From: Daun Johnson
Sent: 18 May 2018 13:09
To: Planning Scanning
Subject: FW: Further Information Required on Your Ref: PP-06860780 Our Ref: WA/39/18/PL
Attachments: 03A Location and Block Plans.pdf; 04 Rear fence and gate elevation.pdf; Shed Detail.pdf

Planning Application reference WA/39/18/PL
'Extension of existing dwelling to create 1 No. attached dwelling' at 48 The Meadows, Walberton

181260/03

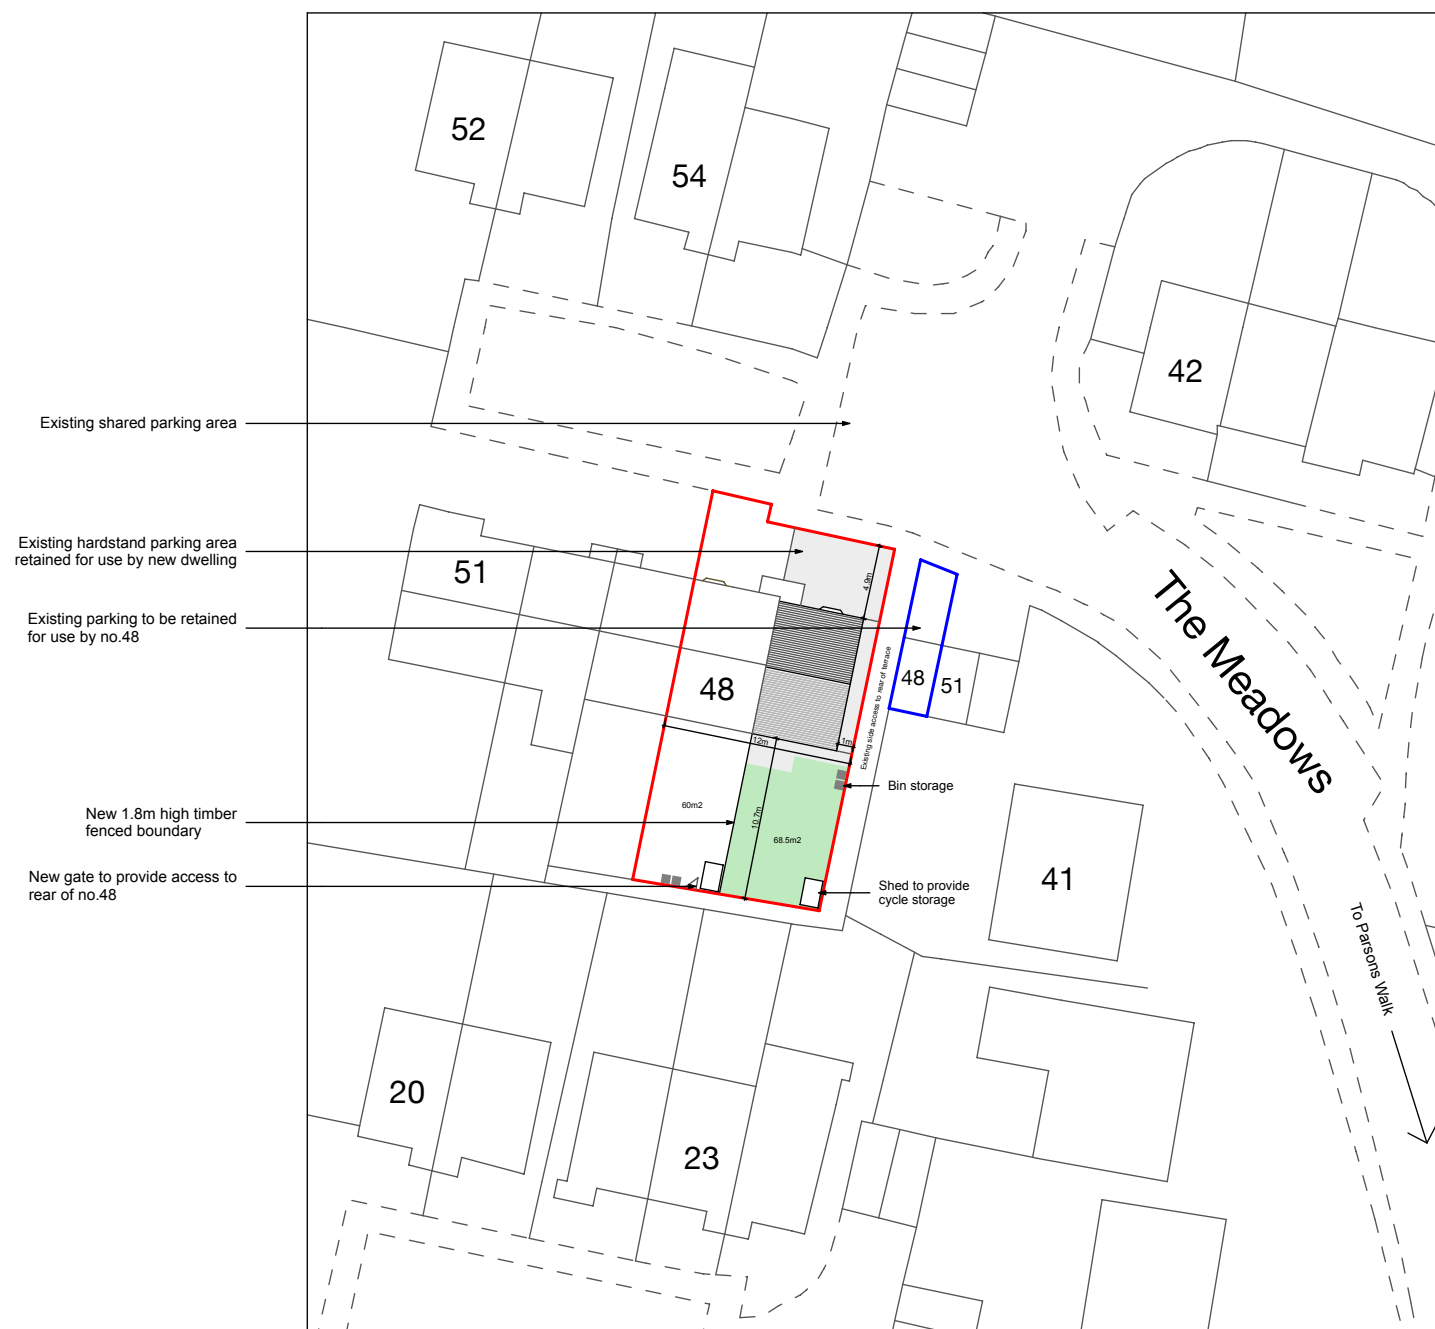
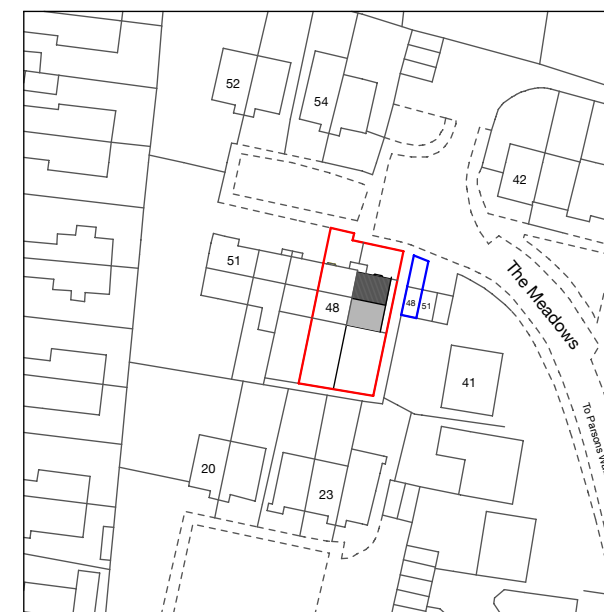
1. **Location plan amend. Please blue edge the existing car parking for use by No 48:** In this respect please find attached updated drawing no. '181260/03 Rev A'
2. **Please provide an elevation for the proposed fence and gate:** In this respect please find attached additional drawing no. '181260/04'
3. **Please provide floor plans and elevations for the proposed shed:** It is understood from your discussions with Mr Fuller that the attached 'Shed Detail' document, which provides a visual representation of the proposed shed structures, will be sufficient for planning purposes.
4. **Foul Water Drainage Statement:** I can confirm that the proposals in this regard are to connect the new dwelling to the existing mains sewer. Consequently, it is understood that this information should be sufficient, and no statement is required.
